Consultation Response from KC Conservation and Design		
2019/91239 The Shears, 201, Halifax Road, Hightown, Liversedge, WF15 6NR		
Demolition of existing public house and erection of four dwellings		
Date Responded: 24/03/21	Responding Officer: Craig McHugh	Responding Ref: The Shears

TITLE  
 EXISTING GF & FF PLANS

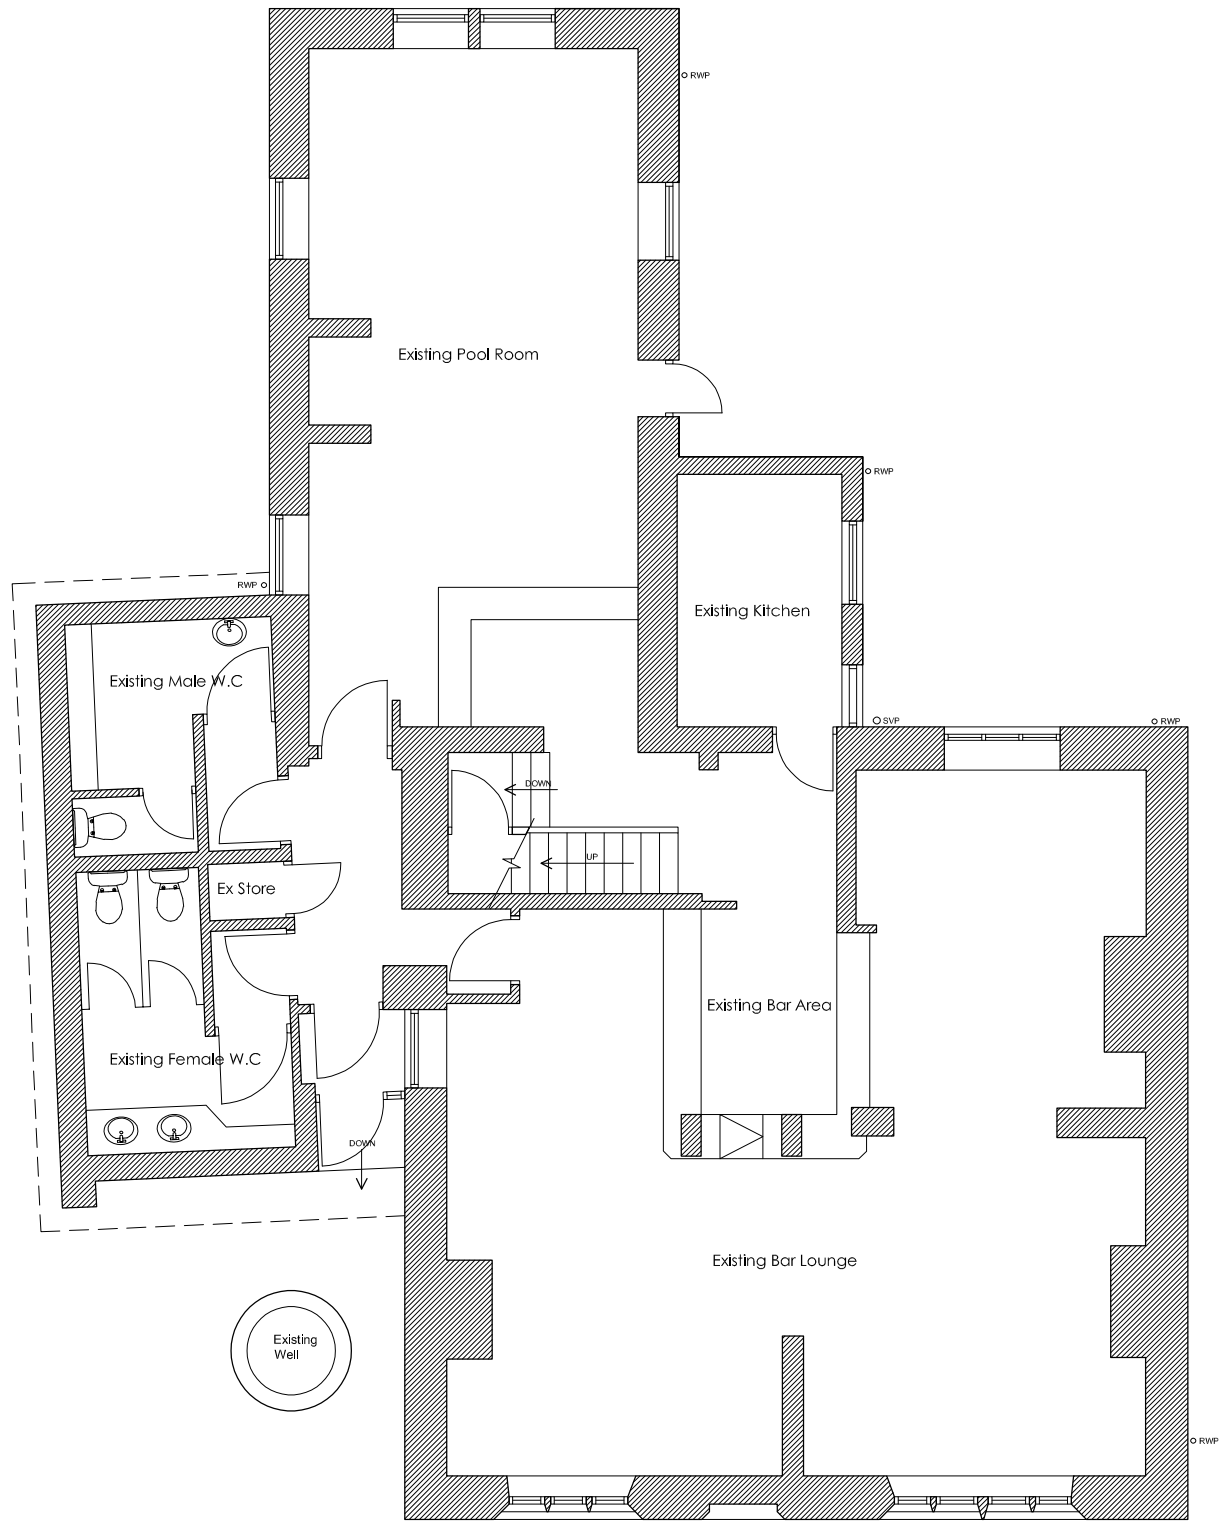
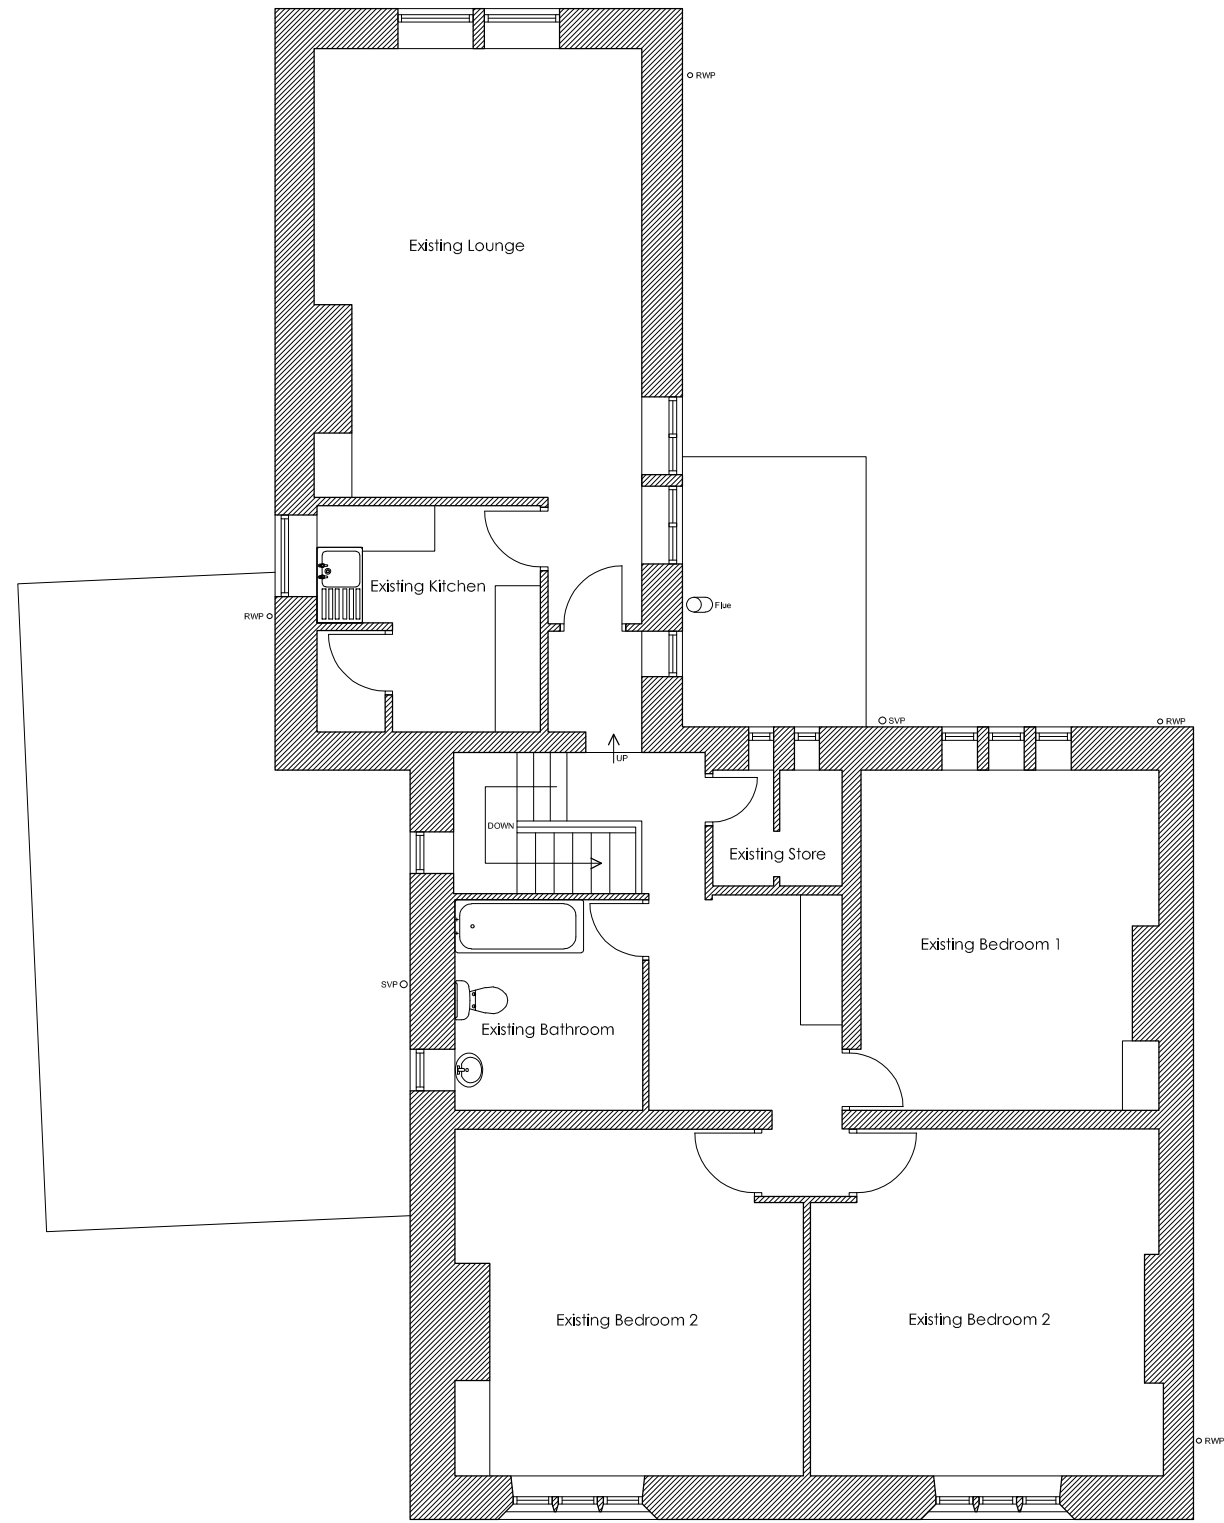
The Shears is a non-designated heritage asset with historic significant interest. It is recorded in the West Yorkshire Historic Environment Record. The Shears Inn was originally constructed as a dwelling for William Howlgate, shopkeeper of High Town and his wife Sarah, their initials are recorded on the datestone .H. W.S 1773. William Howlgate died in 1776. By 1803 part of the building was in use as a public house. The history of the Luddite Movement is clearly of national historic interest and The Shears had an important and well-documented part in the history of that movement in Yorkshire and the events of 1812. The interior of the inn has been much altered since that time. However, the plan form of the building as a double-fronted double-pile plan house (two rooms to front, two to back) can still be read and could be restored.

The proposed development would result in the complete loss of The Shears Inn, a non-designated heritage asset and an Asset of Community Value.

TITLE
 PROPOSED ELEVATIONS - PLOTS 1 & 3

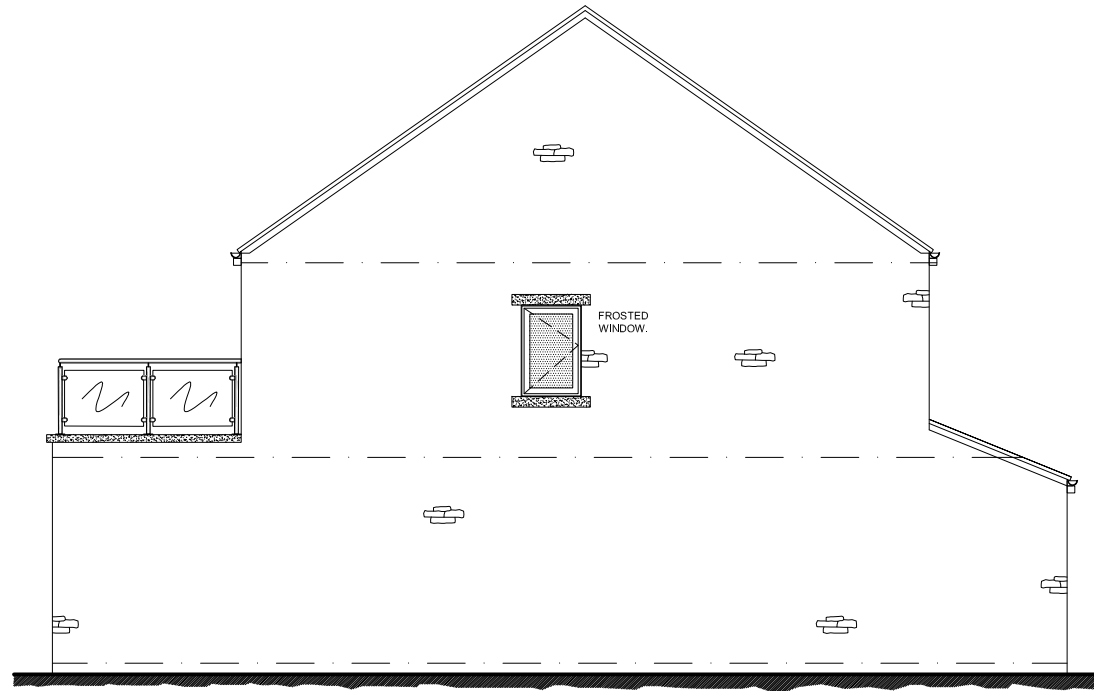
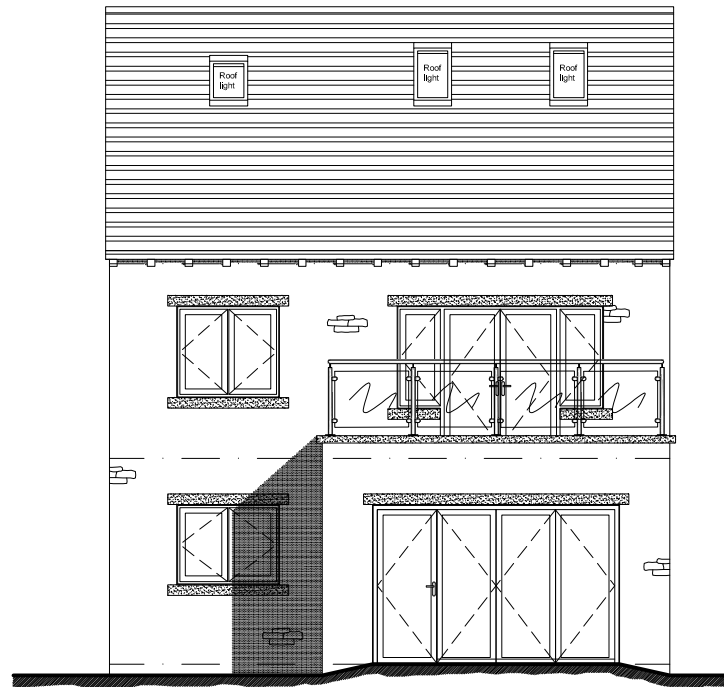
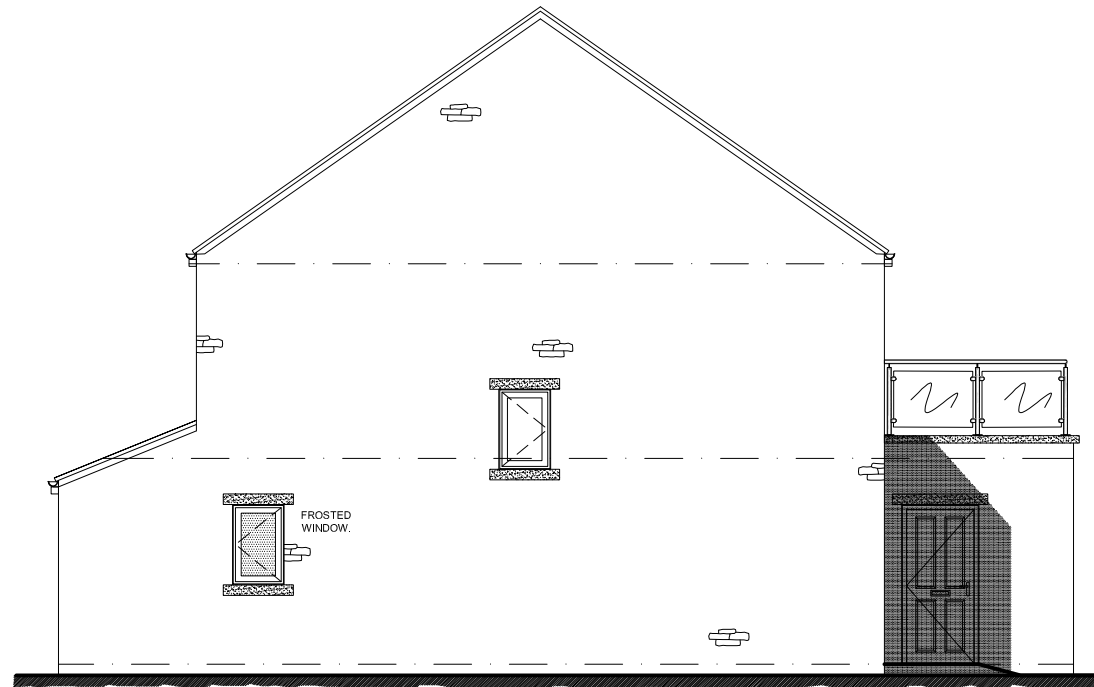
With regards to the form of the development, front porches are not typical in the immediate vicinity. Nor are first floor balconies. I defer to you on the impact these balconies will have on the amenity of neighbours.

The proposed materials are found within the immediate vicinity, generally on later developments that have weakened the townscape. Natural stone walling and stone or slate roofing are more traditional and would better respect local character. One material should be used for all windows and doors. Aluminium would have a lower environmental impact than upvc and is easier to recycle at the end of its life.

TITLE
PROPOSED STREET ELEVATION

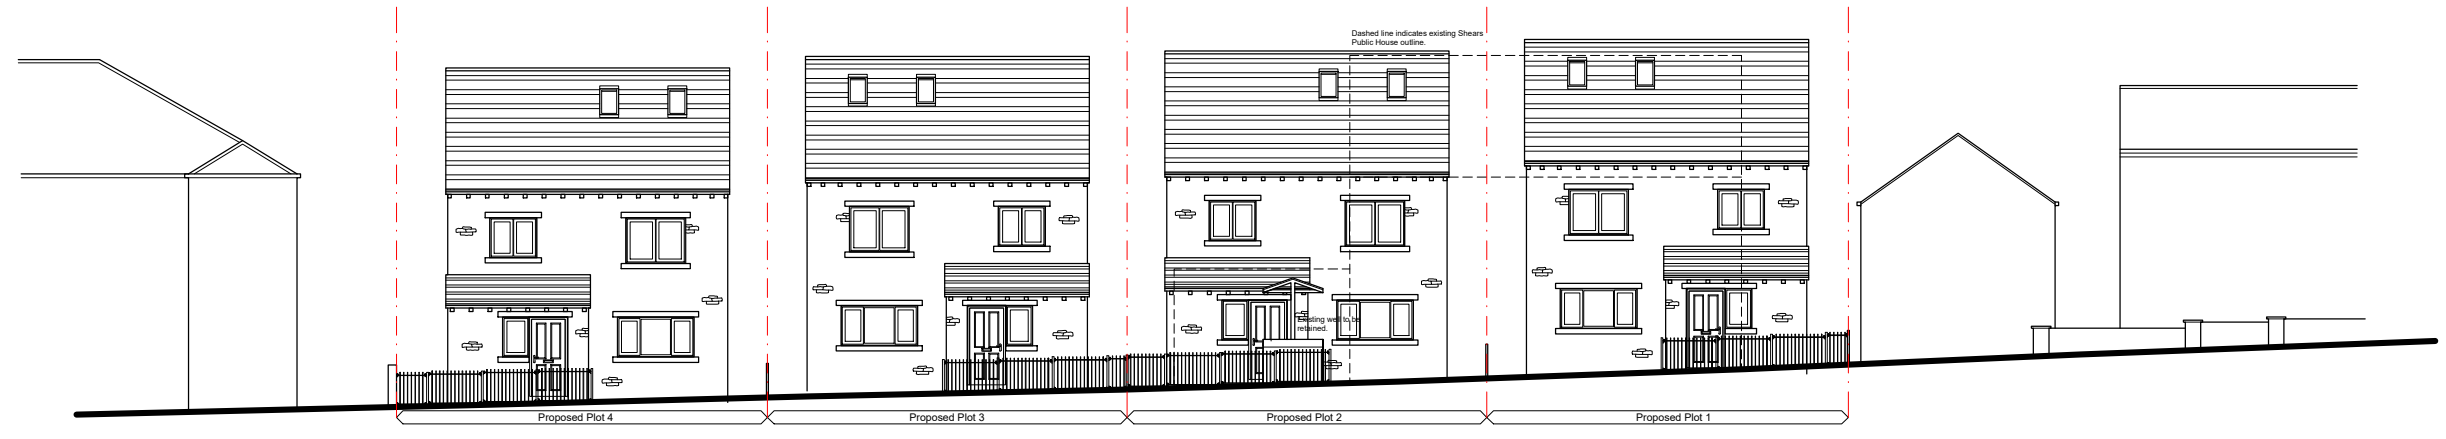
The proposed layout is of particular concern as it would weaken the quality of the local townscape by replacing a building providing strong containment to views with a development set back from the road by about 8m and dominated by parked vehicles. Whilst the townscape of Hightown is varied, short terraced rows and detached properties or semi-detached pairs in larger plots are more common. There does not appear to be a local precedent for development of this type.
